WEST SUSSEX COUNTY COUNCIL CONSULTATION

TO:	Arun District Council FAO: Miss K Welch
FROM:	Highways, WSCC
DATE:	06/08/2026
LOCATION:	B C M Y Ltd, Unit 1 Fort Road, Littlehampton, BN17 7QU
SUBJECT:	LU/162/26/DOC Approval of details reserved by condition under LU/209/25/S73 relating to conditions 9- Groundwater Monitoring, 10- Surface Water Drainage, 11- Maintenance and Management of Sustainable Drainage Scheme, 12- Surface Water Management and 13- Surface Water Drainage. (See LU/169/26/DOC for conditions 6- Contamination, 14- Cycle Parking and 15- Energy.)
DATE OF SITE VISIT:	N/A
RECOMMENDATION:	Advice

Condition 14 – Cycle Parking

Site Block Plan

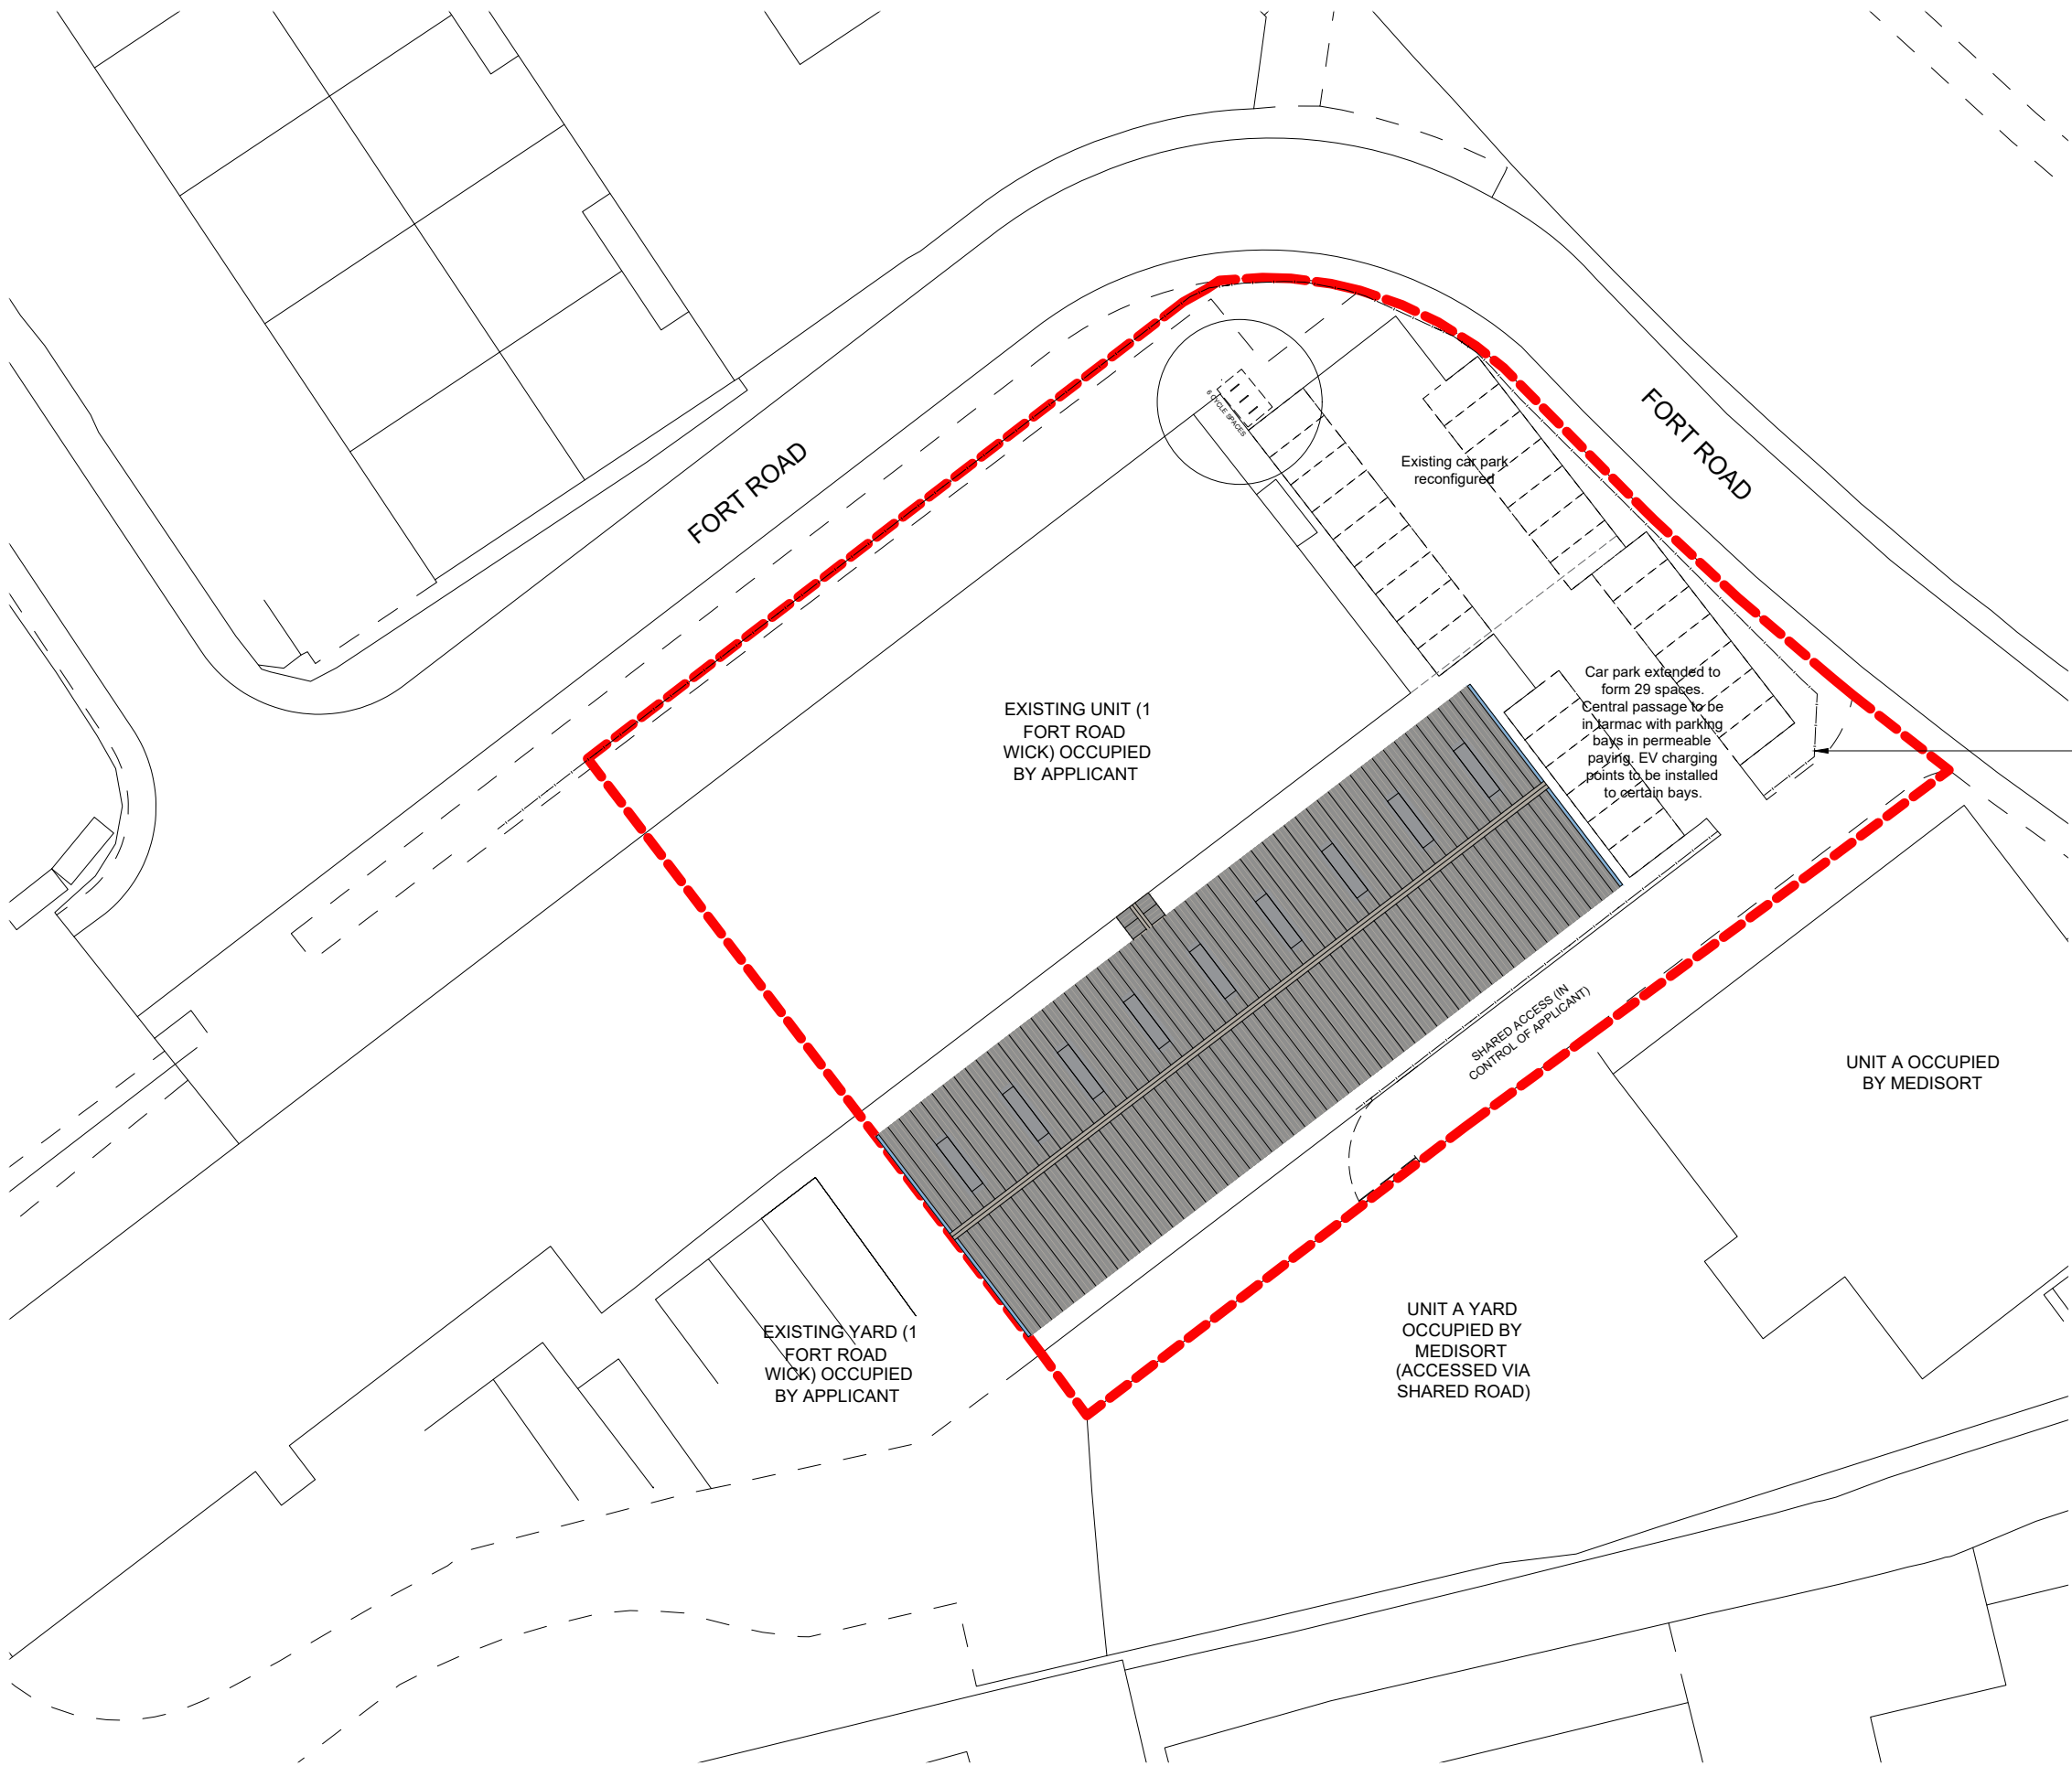
The applicant has submitted a plan demonstrating the location of the proposed cycle parking, which provides for six cycle parking spaces for this development. Whilst the details are accepted in principle, as per the wording of the condition, the proposed cycle parking must be covered and secure. Limited information as to the type of cycle parking provision has been submitted to support this application. As such, the LPA may wish to request further information to ensure that the proposed cycle parking is to be secure and covered.
